WEST SUSSEX COUNTY COUNCIL CONSULTATION

TO:	Arun District Council FAO: Maria Tomalova
FROM:	WSCC - Highways Authority
DATE:	24 June 2021
LOCATION:	240-242 Chichester Road Bersted PO21 5BA
SUBJECT:	BE/82/21/PL 1 No. 2-bed & 2 No. 1-bed flats above shop premises to rear of Truevision. This site is in CIL Zone 4 (Zero Rated) as flats.
DATE OF SITE VISIT:	n/a
RECOMMENDATION:	Advice
S106 CONTRIBUTION TOTAL:	n/a

Location & Block Plans
Two 2-BED & Two 1-BED FLATS
Above Shop Premises To Rear of Tricorvision
240-242 Chichester Rd, Bognor Po21 5BA

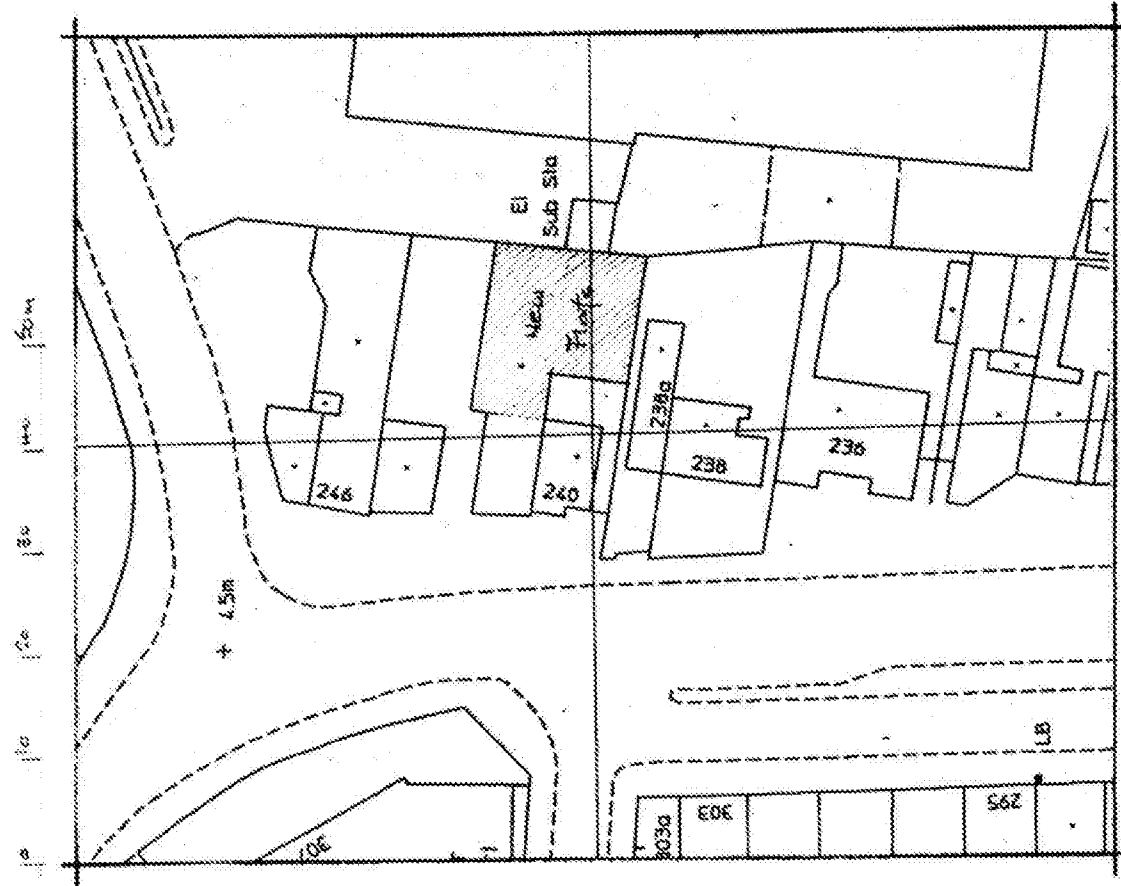
The site is currently accessed from Chichester Road and no alterations to the existing access arrangements are proposed. The site currently has 6 total parking spaces, with two informal spaces for retail customers on the site frontage and four spaces to the north of the site, accessed via a side access. The Design and Access Statement indicates that this parking provision will be unallocated for use by customers and staff of the retail unit and for residents of the proposed flats; although letting preference will be given to non-car owners.

Under Arun Parking Standards (adopted January 2020), the LHA would anticipate that 3 parking spaces would be sufficient for a development of this size and location. The internal side access is proposed to be widened at the narrowest point to increase manoeuvrability for vehicles. However, it is noted that the four parking spaces are proposed in an echelon arrangement, and once parked, a vehicle would be blocked in by other vehicles. This makes the parking area inconvenient for residents of the flats, as this arrangement is unlikely to be suitable or practical for multiple households. The Design and Access Statement suggests that any car-owning residents would be able to park in nearby streets within existing on-street parking provision. Whilst the LHA would not raise any highway safety concerns to this arrangement, the LPA may wish to consider the potential impact of this proposal on on-street parking.

No part of the development shall be first occupied until the car parking has been constructed in accordance with the approved site plan. These spaces shall thereafter be retained at all times for their designated purpose.
